## WEST SUSSEX COUNTY COUNCIL CONSULTATION

<b>TO:</b>	Arun District Council FAO: Mr. S. Davis
<b>FROM:</b>	WSCC – Highway Authority
<b>DATE:</b>	03 April 2025
<b>LOCATION:</b>	Land adjacent to Woodgate Nurseries Lidsey Road Aldingbourne PO20 3SU
<b>SUBJECT:</b>	AL/143/24/RES Approval of reserved matters following outline consent AL/129/21/OUT for 95 No residential dwellings with associated parking, landscaping, open space (including play areas), infrastructure and works. This application is in CIL Zone C and is CIL Liable as new dwellings.
<b>DATE OF SITE VISIT:</b>	n/a (desktop study undertaken – site visited at outline stage)
<b>RECOMMENDATION:</b>	Further information required/modifications recommended

This is the second WSCC Highways response to the above planning application seeking approval of reserved matters following outline consent AL/129/21/OUT for 95 No residential dwellings with associated parking, landscaping, open space (including play areas), infrastructure and works.

A	Screen fence Hedgehog Highway added	03.03.25	SW
Boundary Treatment Details			
Project:	Lidsey Road - Phase 1	Woodgate	
Client(s):	BDW Southampton		
Drwg No:	ST-22-14	Rev:	A
Scale:	1:20 @ A1	Date:	10.09.2024
Drawn By:	SW	Checked By:

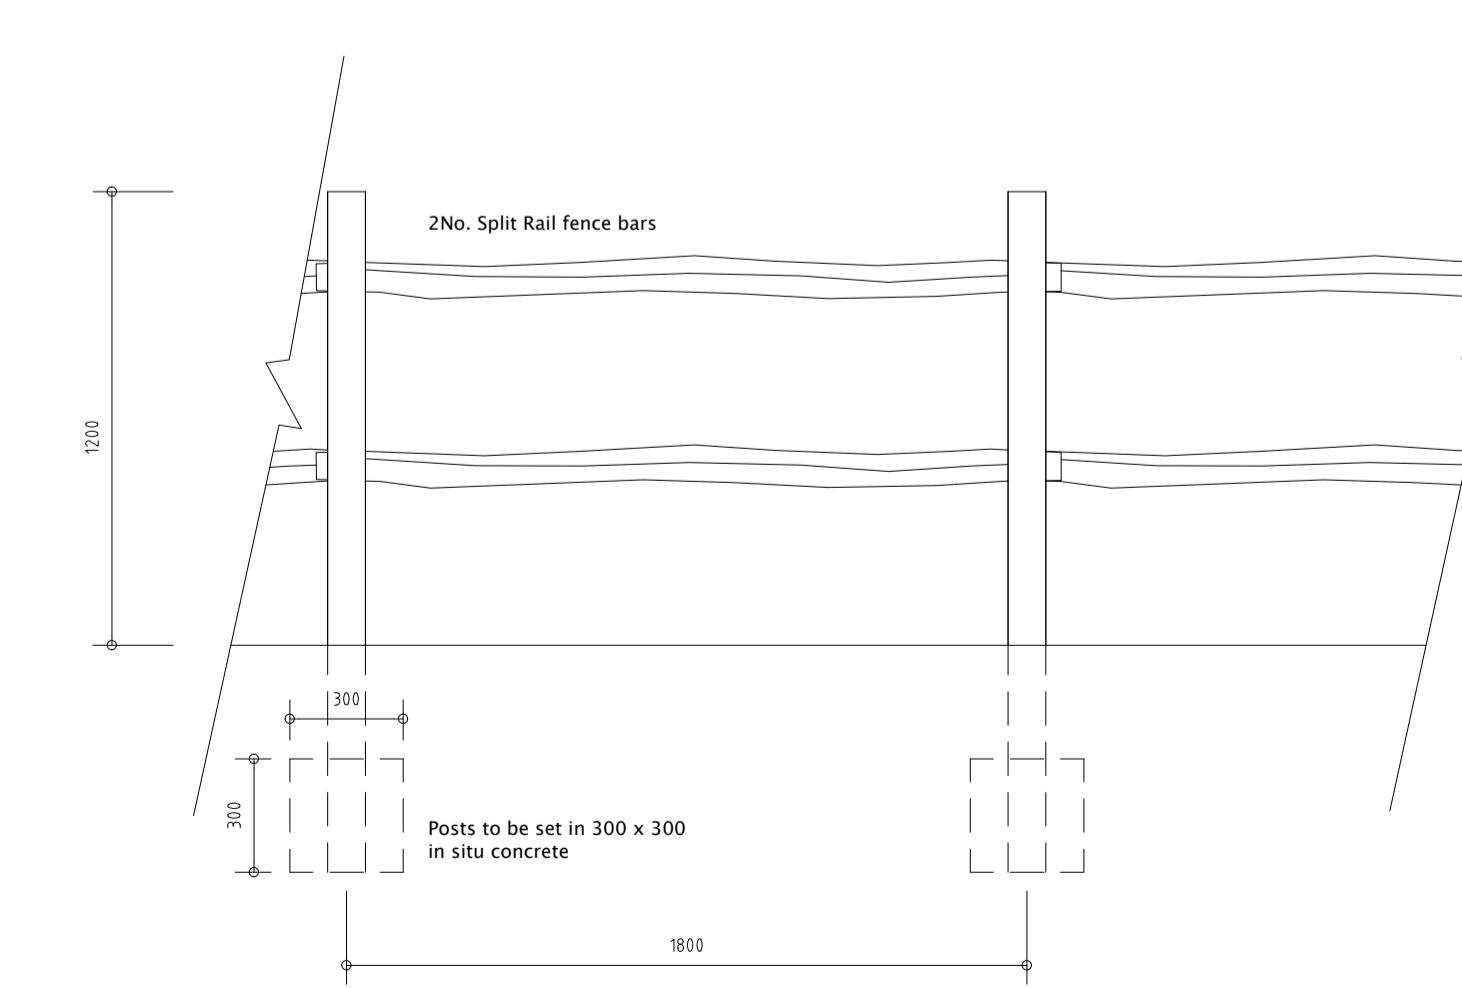
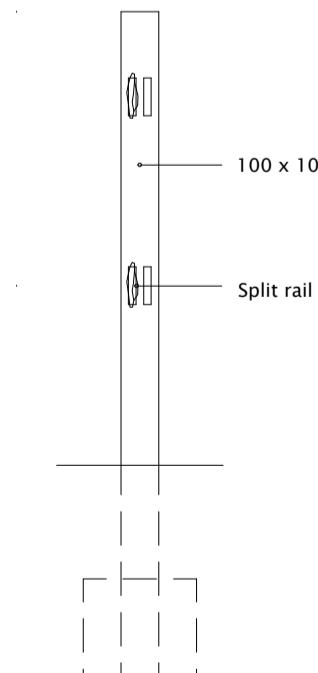
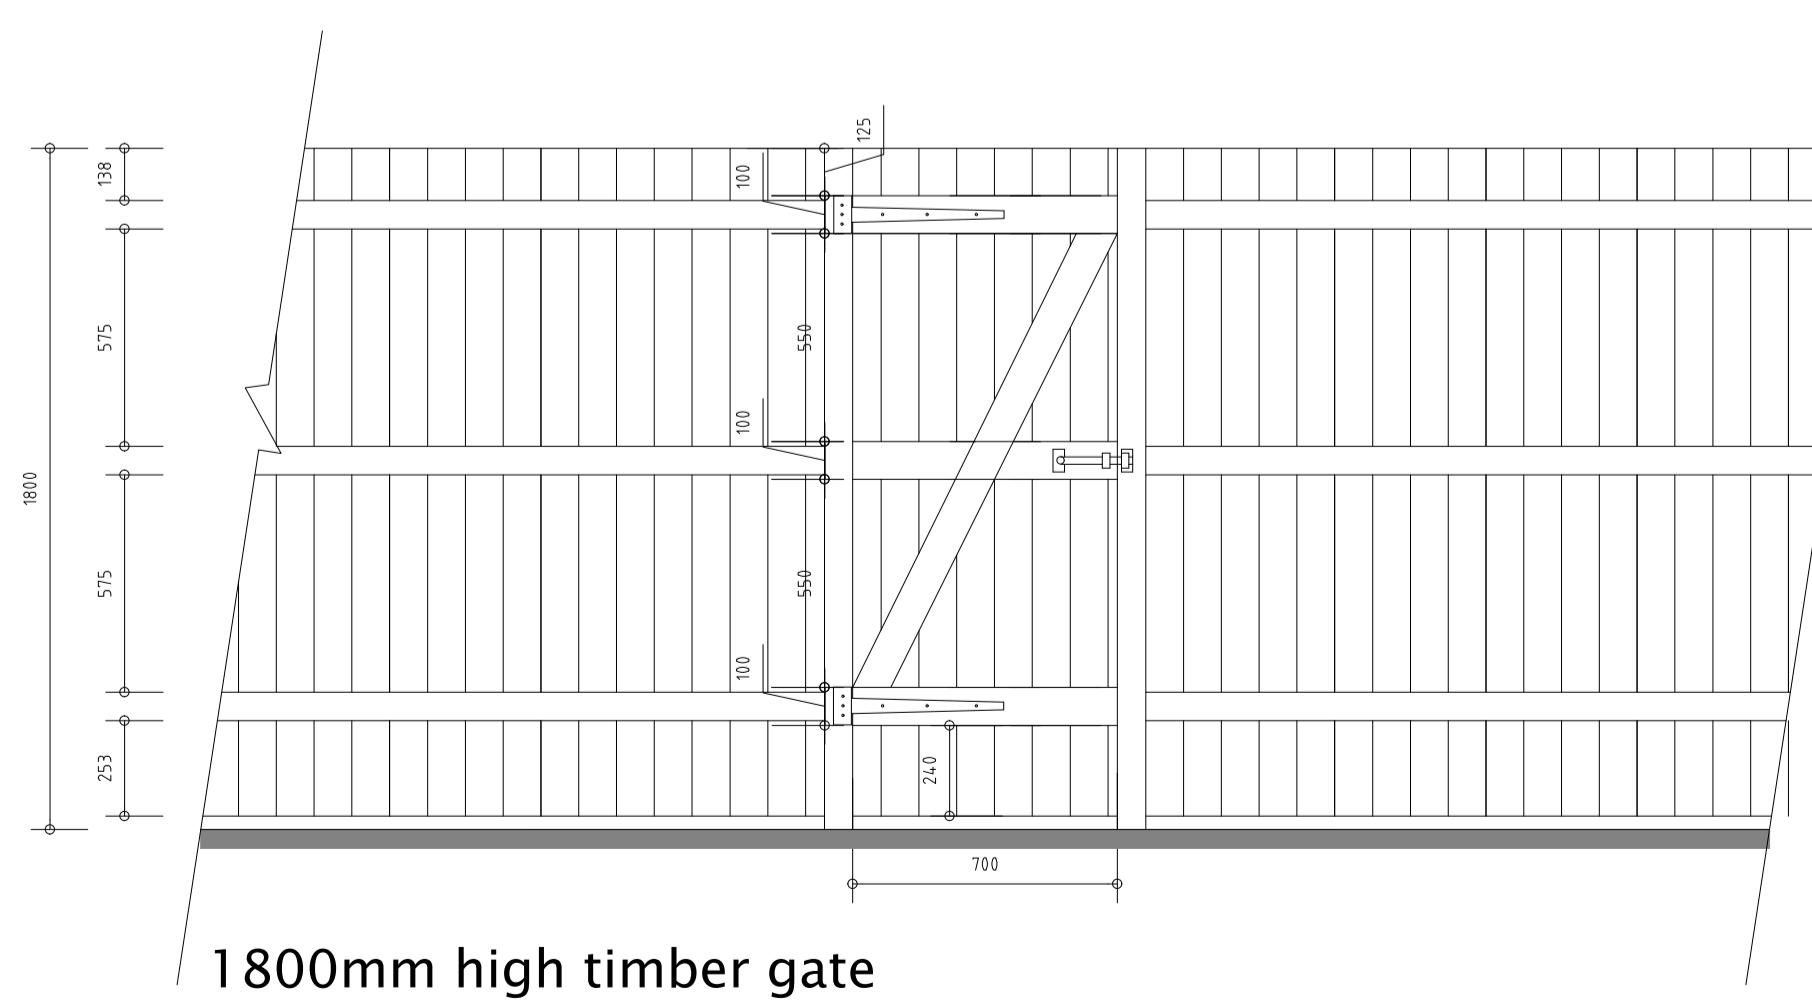
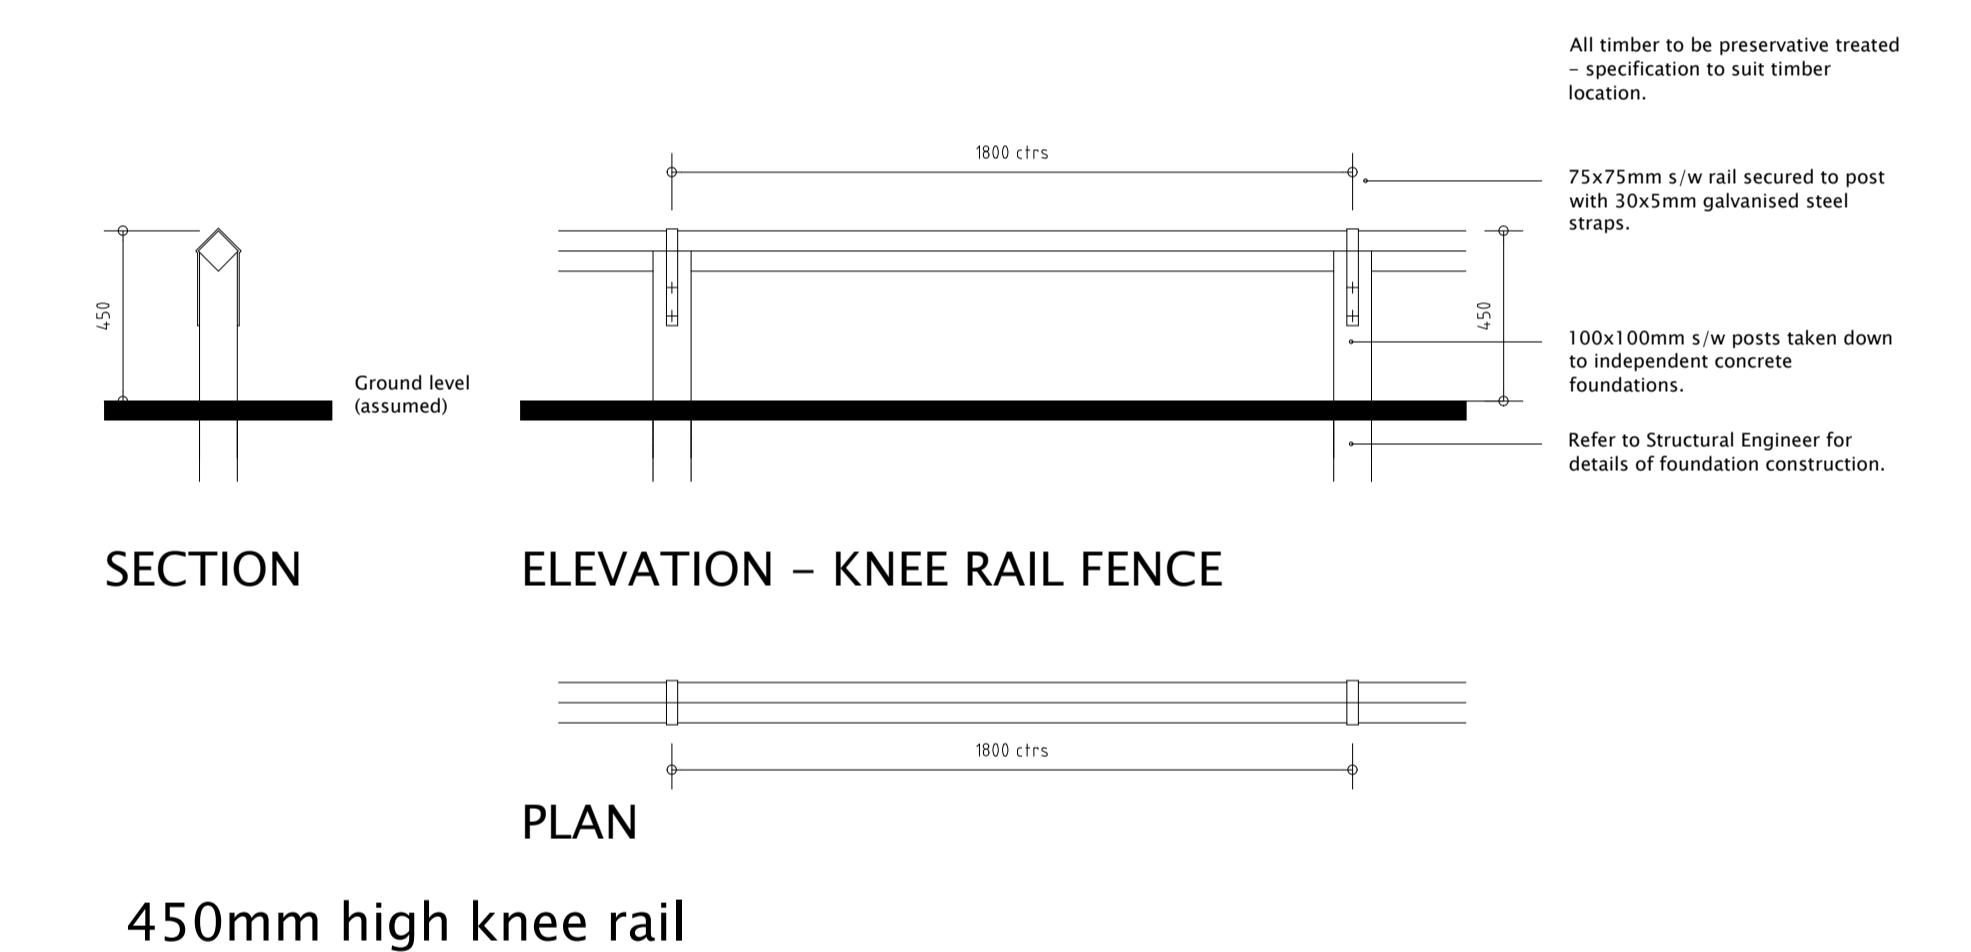
- Recommend in front of plots 6-9, 58 and 59, that a shared surface road be installed instead of tarmac. **Applicant response:** The area adjacent to plot nos. 6-9 has now been shown as shared surface with block paving, as requested. The area on the vicinity of what was plots 58-59 (now 56) does not have the opportunity to include an additional raised table given that any ramp location would clash with drive accesses, but an additional length of block paving has been added in front of plots 57-58. *Noted – but extra length of block paving has not been shown outside plots 57 and 58.*
